**KIRKLEES METROPOLITAN COUNCIL
INVESTMENT & REGENERATION SERVICE**

Reference No: 2020/44/90682/W

Site Address: Croft Medical Centre, Cobcroft Road, Fartown,
Huddersfield, HD2 2RU

DECISION – DISCHARGE OF CONDITIONS 5 AND 6

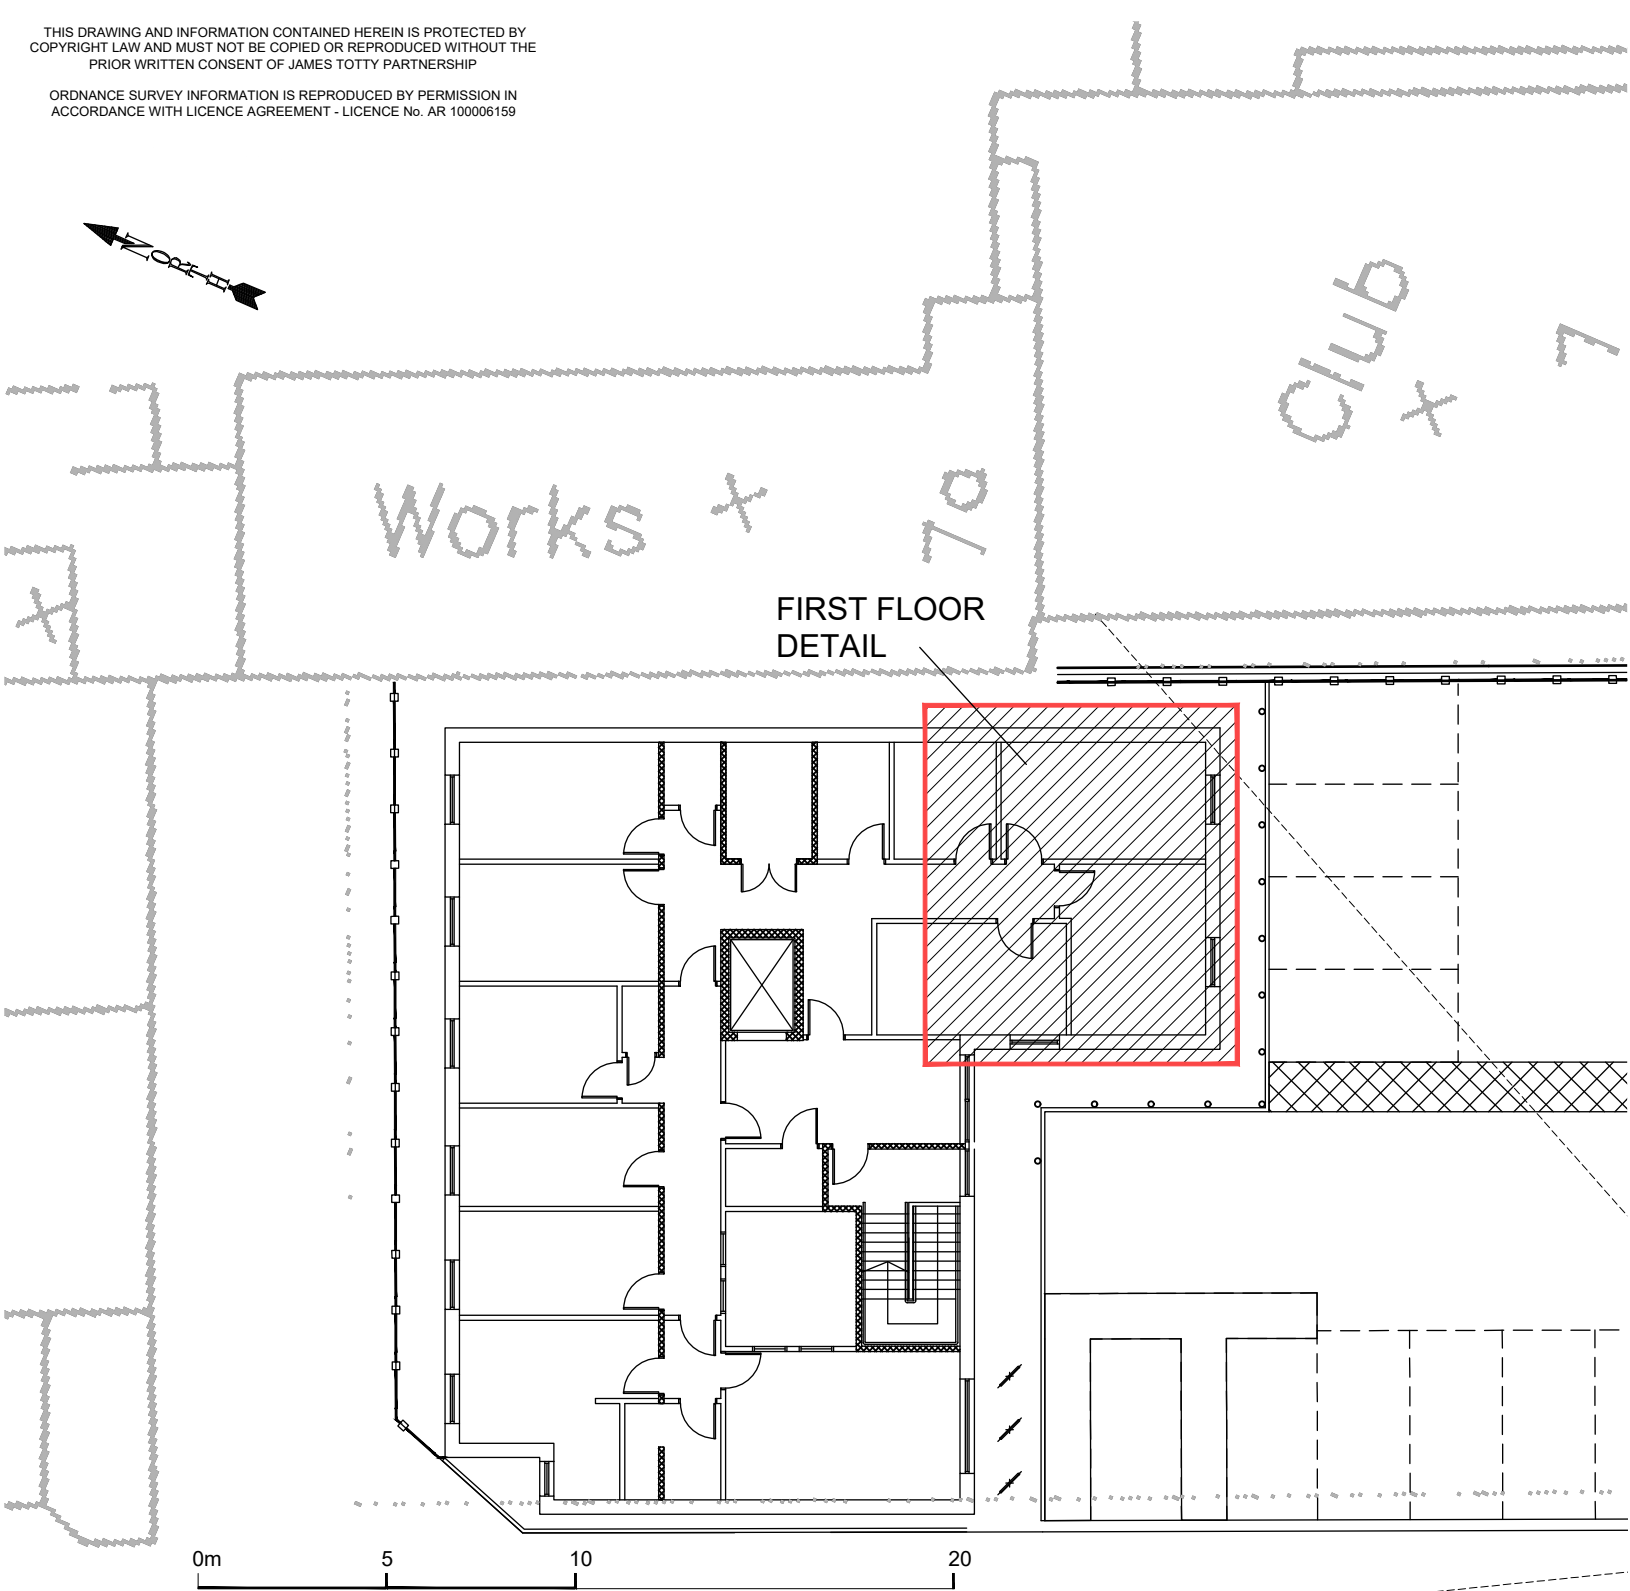
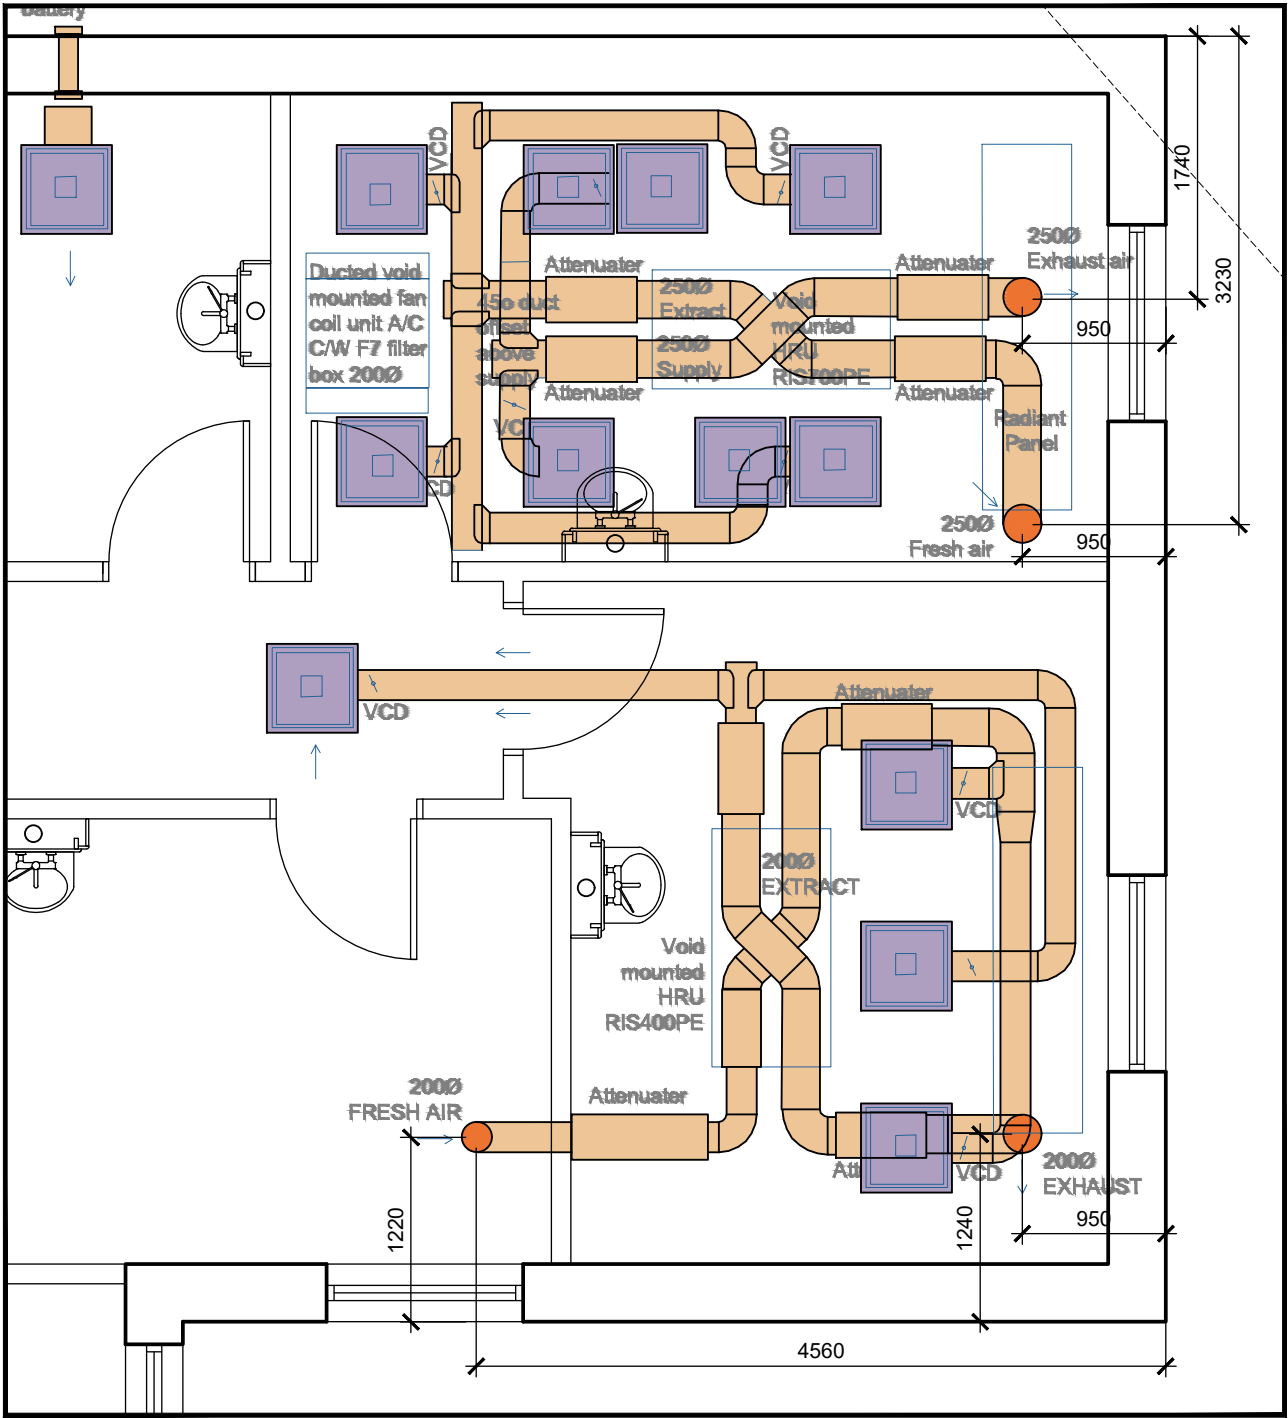
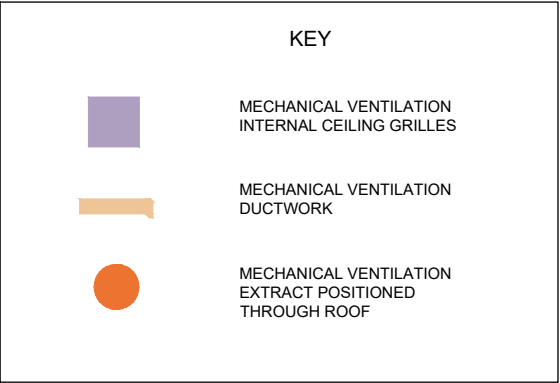
The ENIA report states that the levels associated with the proposed ventilation “*are at least 13 dB below the otherwise prevailing background levels*”. In such circumstances the submitted details are satisfactory to discharge condition 5 subject to the units being installed in accordance with the agreed details and retained as such thereafter.
